**Re: N6/2012/2652/FP  
W6/2012/2653/EM  
35 Sherrardspark Road**

We are writing to express our objection to the above applications. We note that these are revised applications following the withdrawal of application N6/2012/1688/FP in October 2012. The nature of the new applications is essentially the same as the previous one, and we refer you to our previous letter of 3 September 2012 (attached) and accompanying photographs. In addition to the concerns we set out in that letter, we would like to make the following additional comments having read the documentation for the new applications.

PROJECT	35 Sherrards Park Road
DRAWING TITLE	Proposed Elevations REVISION D
STATUS	Pre - Planning
SCALE 1:100 @ A3	DRAWN BY AM 08 - 004PD

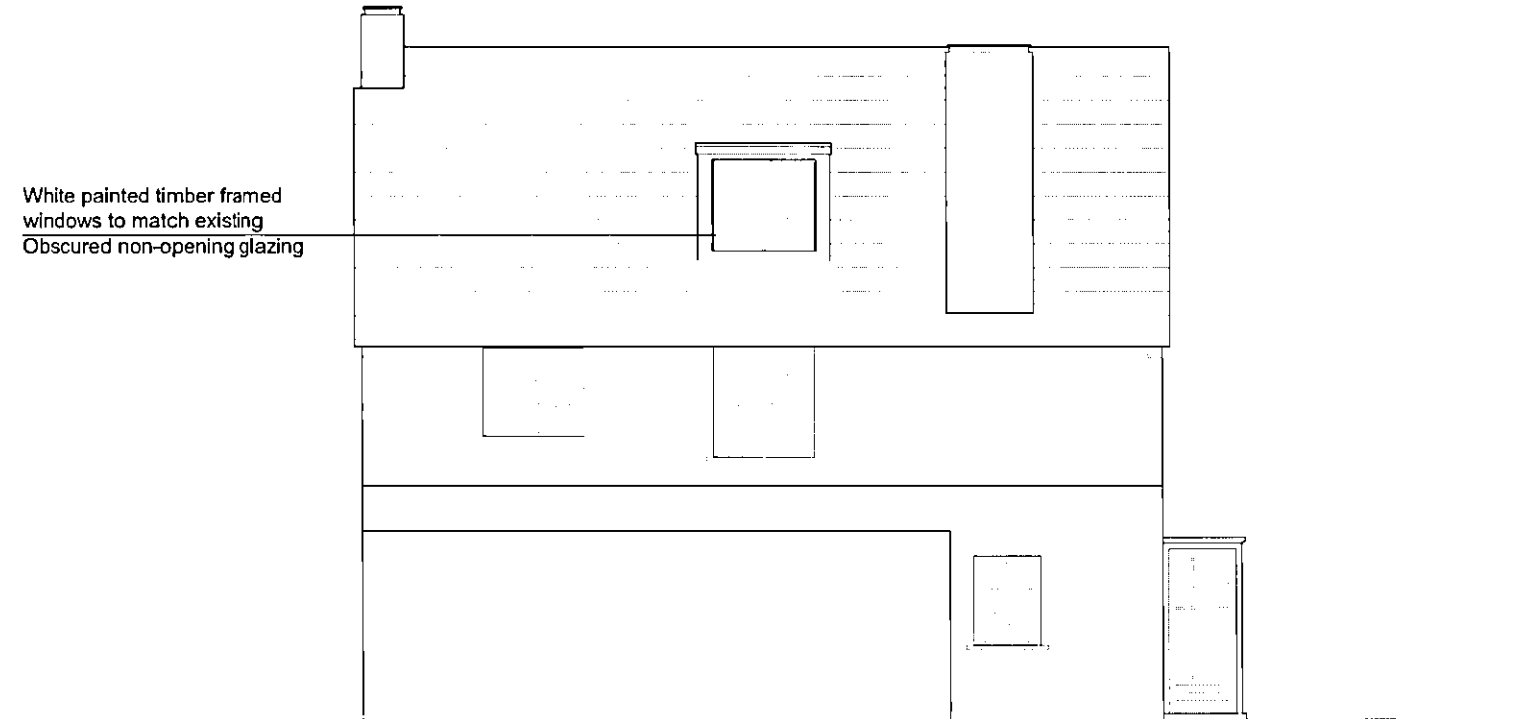
As previously noted, the photograph on the front page of the Design and Access Statement does not show the side of the roof where the proposed dormer window would be constructed. We think it would be more appropriate if you saw a photograph taken from the other side, where the impact on our property could clearly be seen (we refer you to photographs labelled 1 and 2 which were originally enclosed with our letter of 3 September and copies of which are included with this one).
